**Northside Private Hospital, West Gosford (SSD-10159) (Central Coast)**

Thank you for your request via ePlanning Portal (ref: PAE-2085) dated 18 February 2020 requesting Transport for NSW (TfNSW) review and comment on the Environmental Impact Statement (EIS) supporting a State Significant Development (SSD) application for Northside Private Hospital, West Gosford.

## ATTACHMENT A

Figure 37 Bicycle and Pedestrian Shared Path in Stage 1

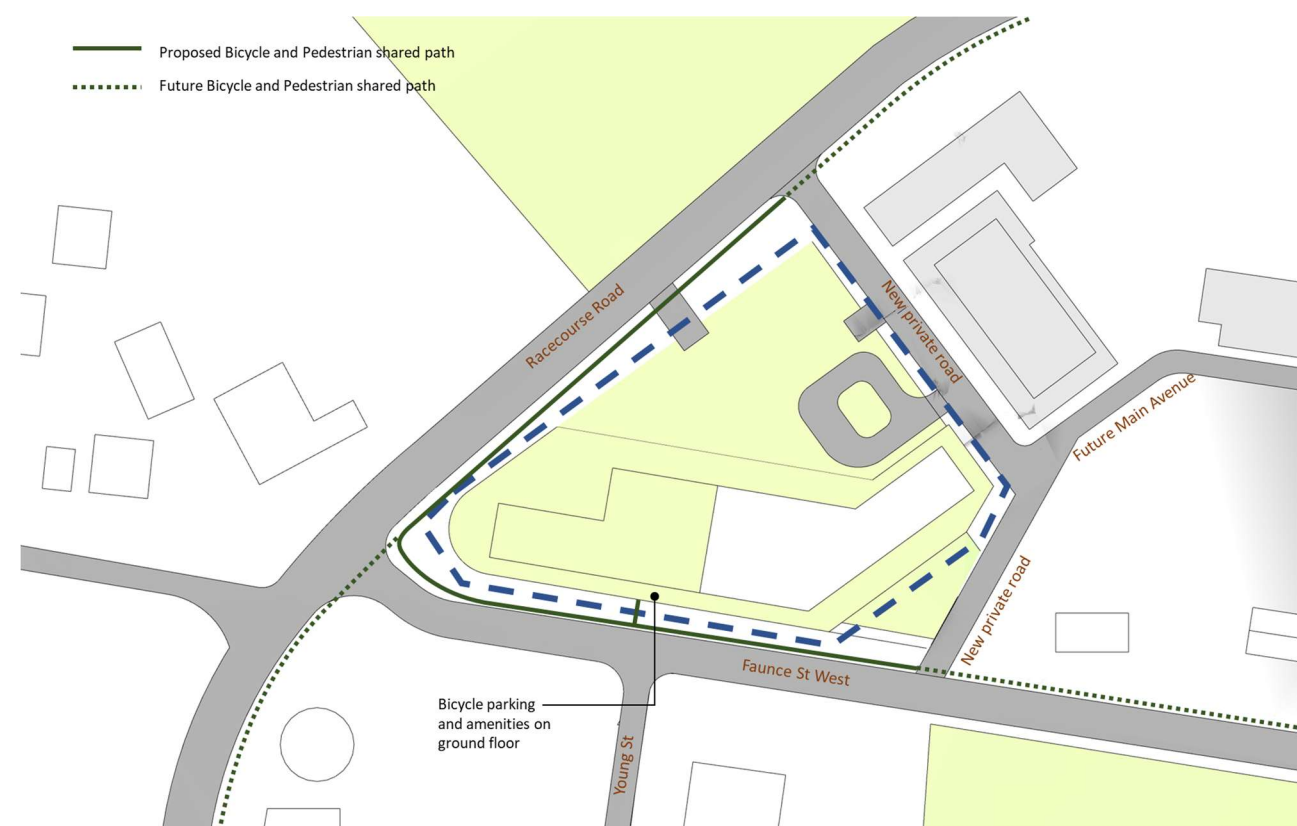
It is requested that the applicant be conditioned to provide bicycle parking and end of trip facilities for staff and customers in accordance with Gosford Council Development Control Plans, standards and guideline documents including:

- Locate bicycle facilities in secure, convenient, accessible areas close to the main entries incorporating adequate lighting and passive surveillance and in accordance with Austroads guidelines;
- Provide signage/marked walkways to the hospital from the car park; and
- Update the Architectural package to show where these facilities will be located.

Figure 39 Vehicular Traffic in Stage 1

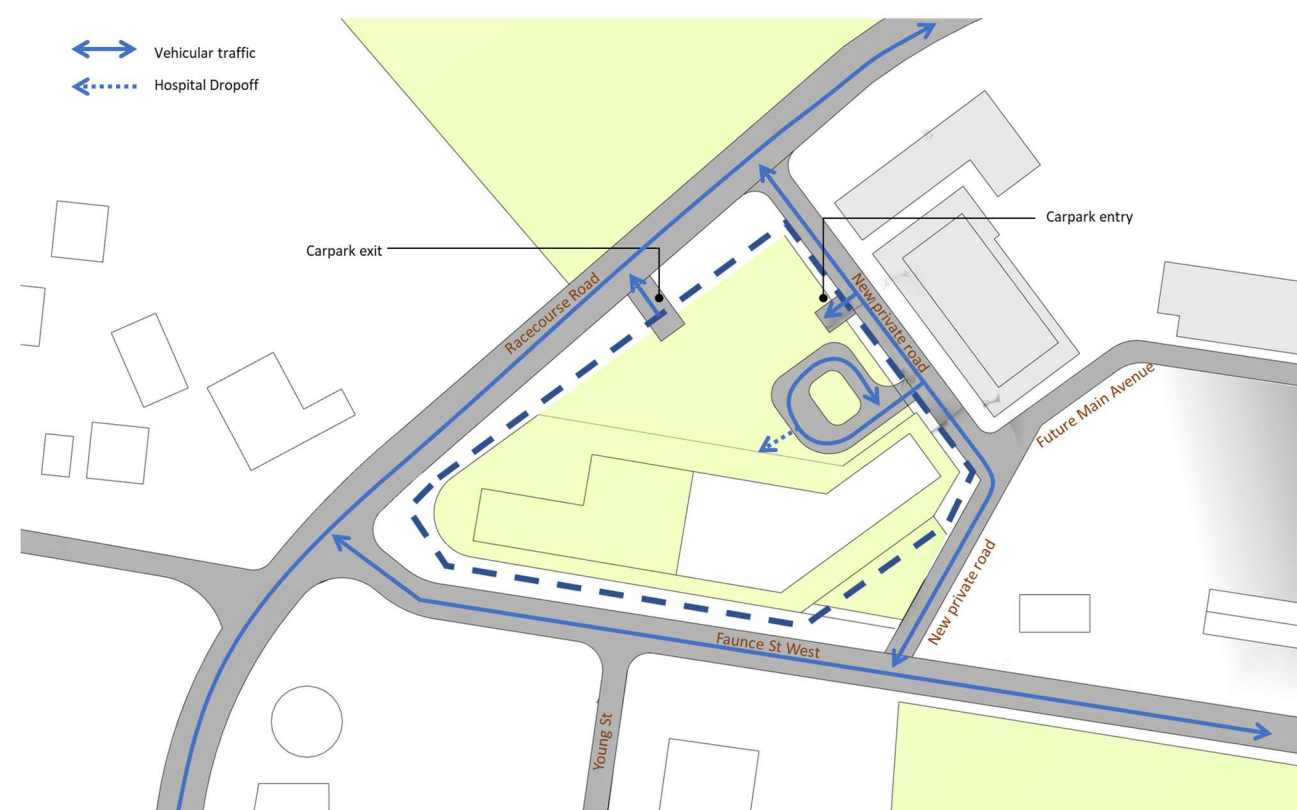
TfNSW does not support access to Racecourse Road in the location proposed. The sight of the proposed access is compromised by the alignment of Racecourse Road, and accesses to the classified road corridor should be limited.

The seagull intersection proposed with the site access (Table 11) is not appropriate for an urban location, and the width of Racecourse Road would not allow for a seagull compliant with Austroads Guidelines to be provided.

It is requested that the applicant be conditioned to provide all access to Northside Private Hospital to / from Faunce Street, and an upgrade of Racecourse Road and Faunce Street should be provided to Council's requirements. Additional emergency vehicle only direct access to Racecourse Road can be considered subject to design.
